WISWELL PARISH COUNCIL

Planning Application No: 3/2012/0514
Proposed side single storey extension
6 Warrington Terrace, Barrow, Clitheroe, Lancashire, BB7 9BG

PROPOSED LAYOUT

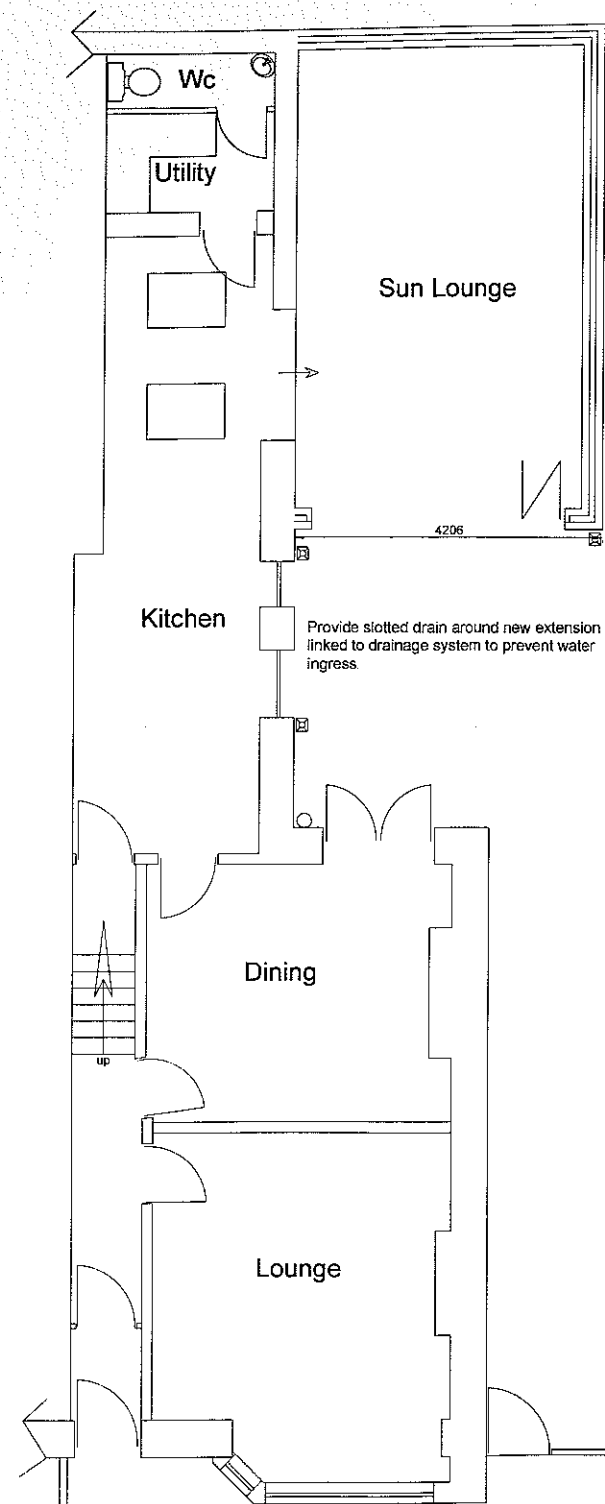
The above application has now been considered by the Parish Council. Although Members have no objections to the scheme in general, they do have some concerns regarding the close proximity of the proposed sun lounge to the side boundary fence of 1 Whiteacre Lane and request that the building should be no higher than the current conservatory.
